From: Hannah Kersley
Sent: 12 April 2022 15:59
To: Planning.Responses; Planning Scanning
Subject: FW: WA/9/22/HH - Midway (Withdrawal email)

I am contacting you regarding the application for a rear extension at Midway, Avisford Park Road (WA/9/22/HH). We have come across a few issues with the documents submitted as part of the application. It appears that the measurements provided by the Arboricultural Survey for tree 1 (Deodar Cedar, protected by a TPO) are incorrect and underestimate the potential harm to the tree. We have consulted our Tree Officer, who believes the root protection area to be much larger than shown by the survey and the Tree plan, and will need more information from you in order to understand the scale of potential harm.

PROPOSED FLOOR PLAN

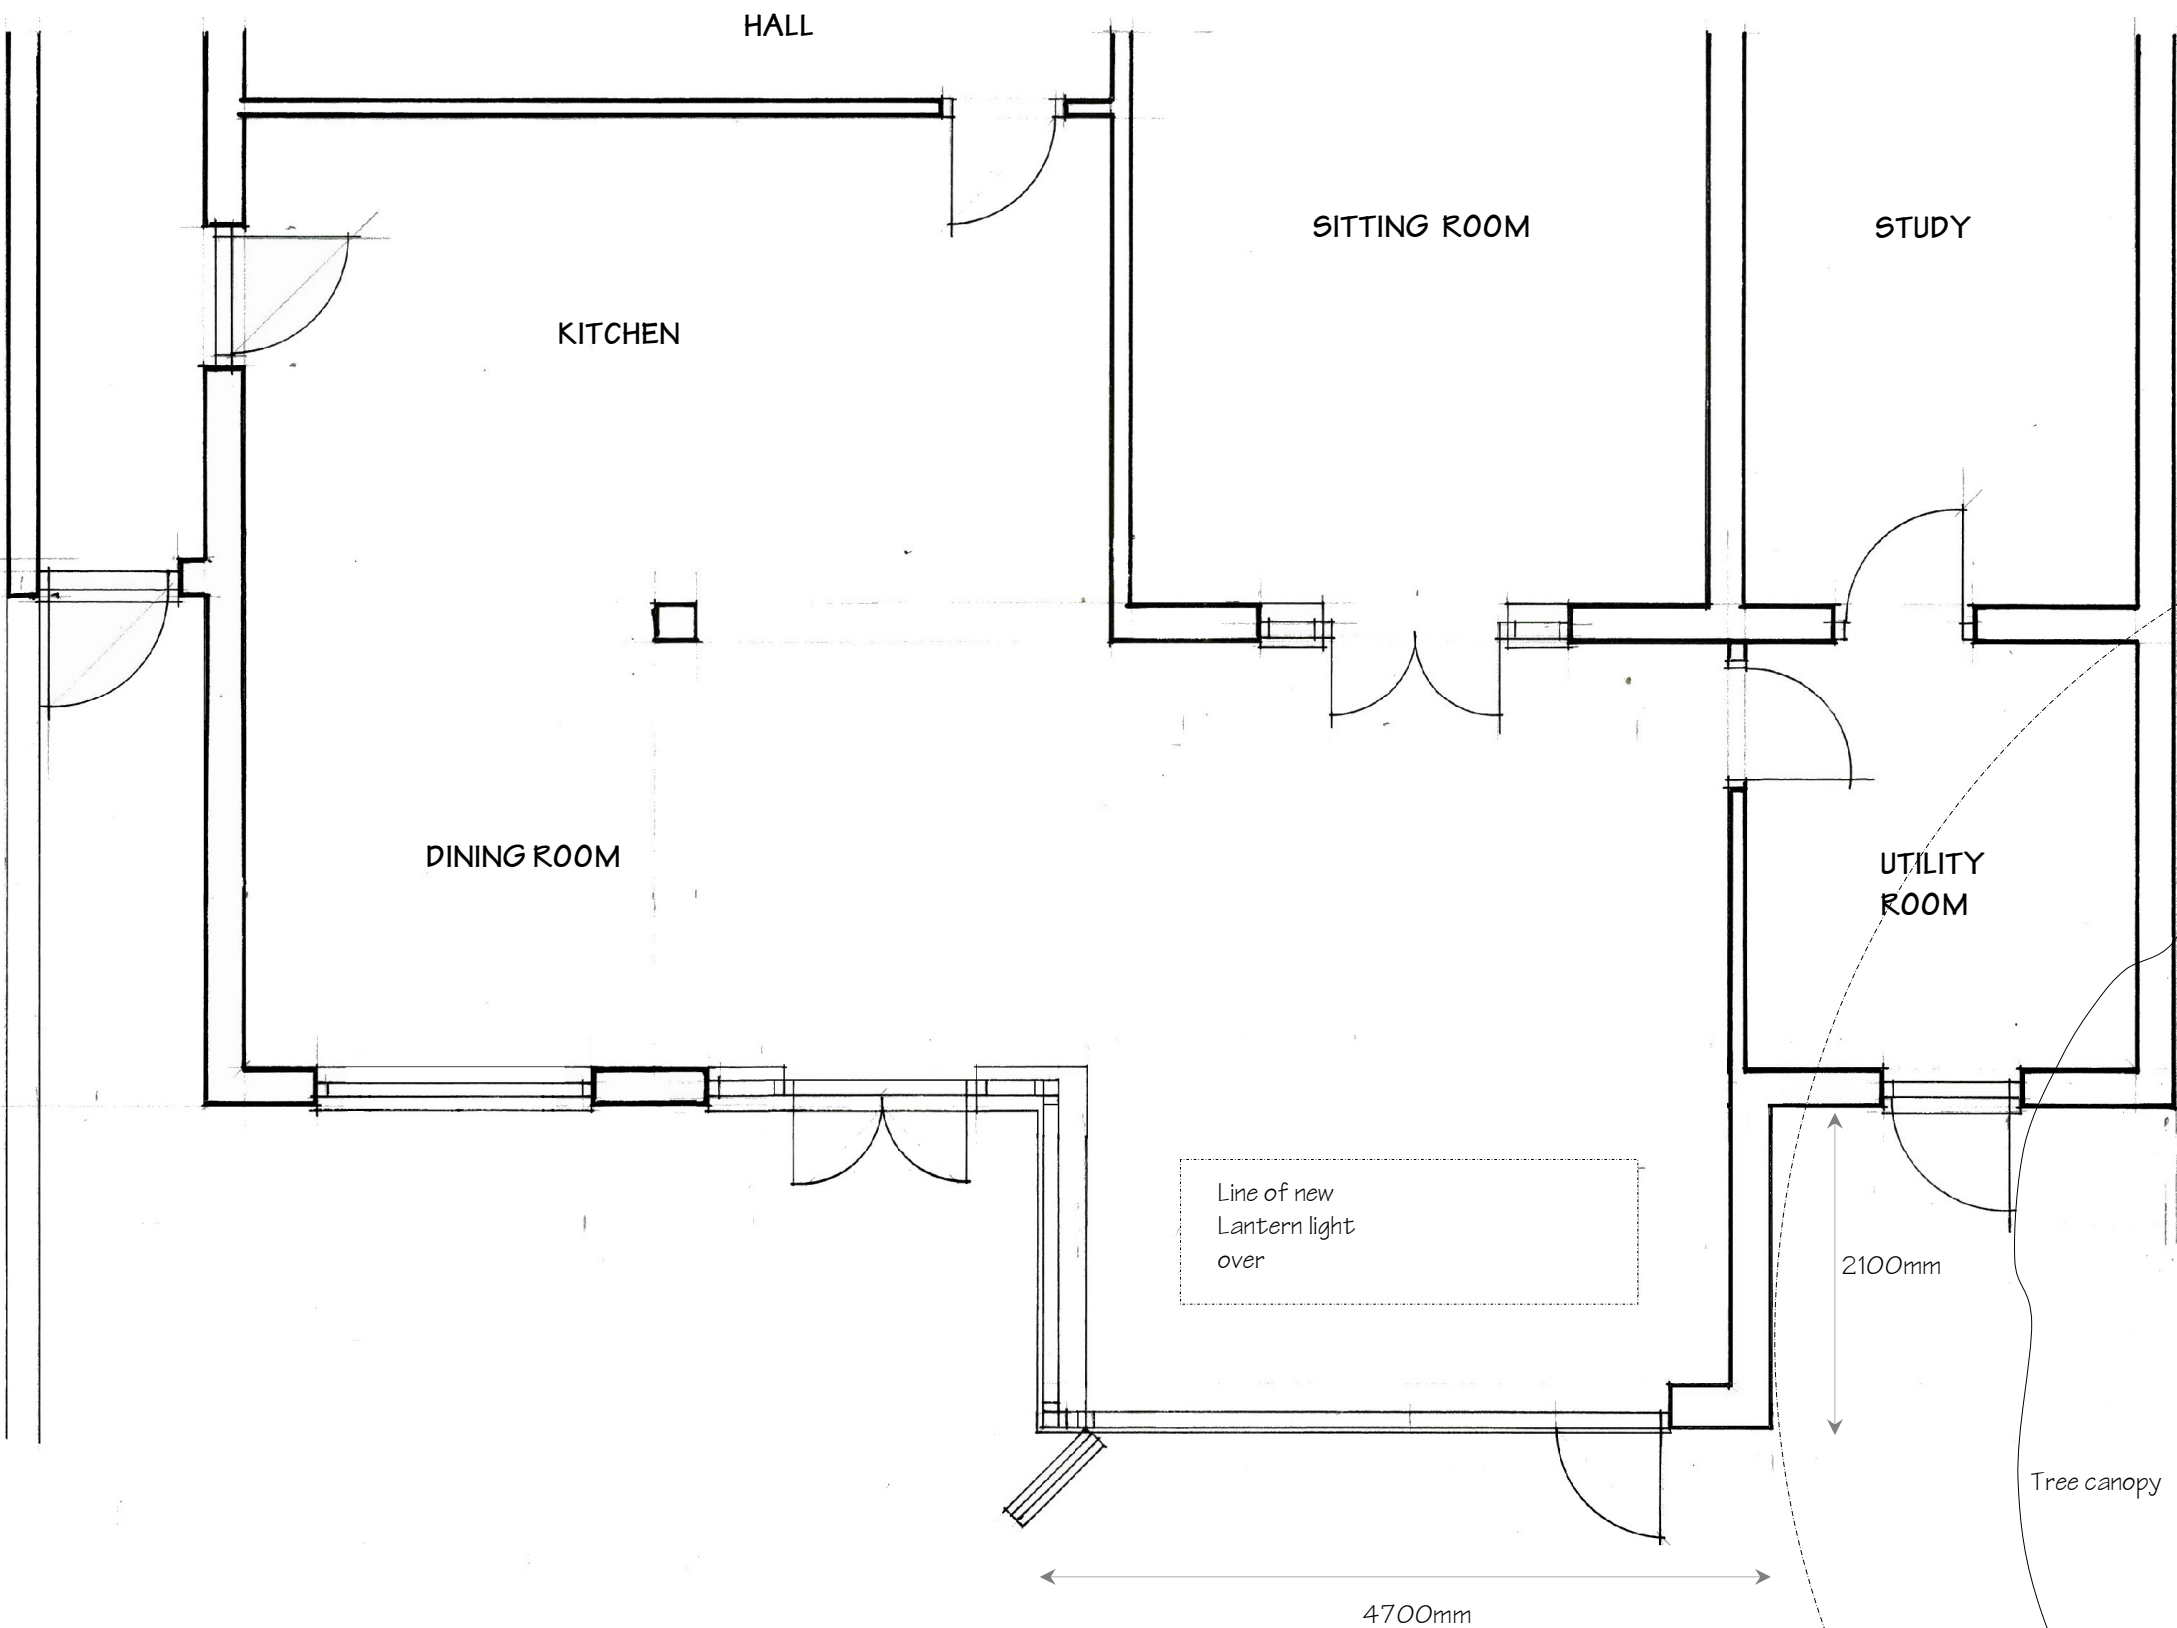
I have spoken to our Tree Officer and he has agreed that both options you have suggested could be acceptable. He has said however that we must first understand the true extent of RPA incursion before encouraging either. The method(s) should also first be promoted by your project arboriculturist, based on their considered assessment of the tree's influence over ground conditions.

An accurate plan with the tree RPA overlayed on the proposed layout will help us to understand the extent better, which I appreciate you have sent a copy of. I believe he wishes this to be more detailed. The RPA on the proposed plans should be presented in polygon form (it does not have to be circular) of commensurate area showing where ground conditions/features heavily influence root morphology (e.g. deep footings, ditches, other trees). This should be similar (but slightly more detailed) to the plan in the revised report, but over the proposed plans rather than existing. There is a possibility that the extent of the RPA incursion is acceptable without any special construction methods but we will need a better understanding of RPA first.

I have attached the revised report and proposed plan, showing the larger protection area. Would either hand excavation / investigation or pile foundations be acceptable to the tree officer?

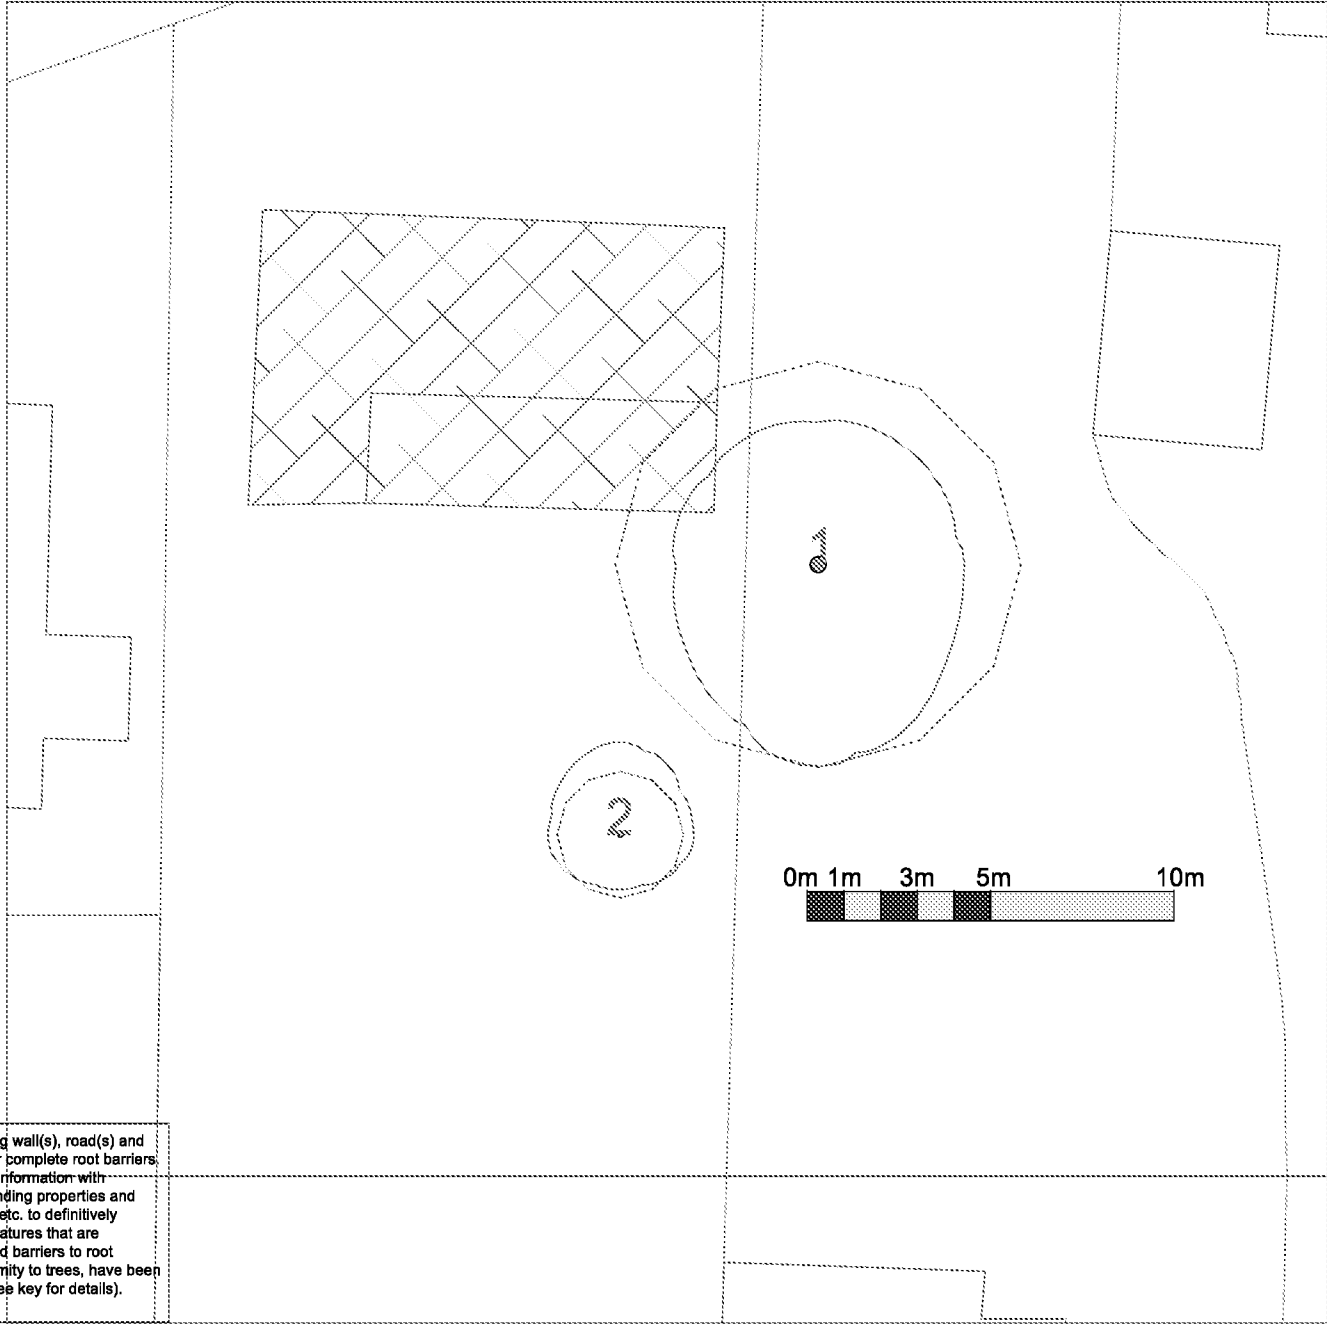
From the Arboricultural Survey, it appears that the tree's size has only been estimated from the garden of Midway, and as a result there has been no accurate measurements taken of the tree from its location on the neighbouring land. We would request that a full inspection is carried out on this tree from the neighbours property, so that the correct measurements can be recorded. We will also need you to submit an accurate Root Protection Area and Tree Protection Plan, in addition to the existing Tree Plan and Arboricultural Survey. These existing documents may also need to be updated and re-submitted if it is found that the existing measurements of the tree are incorrect.
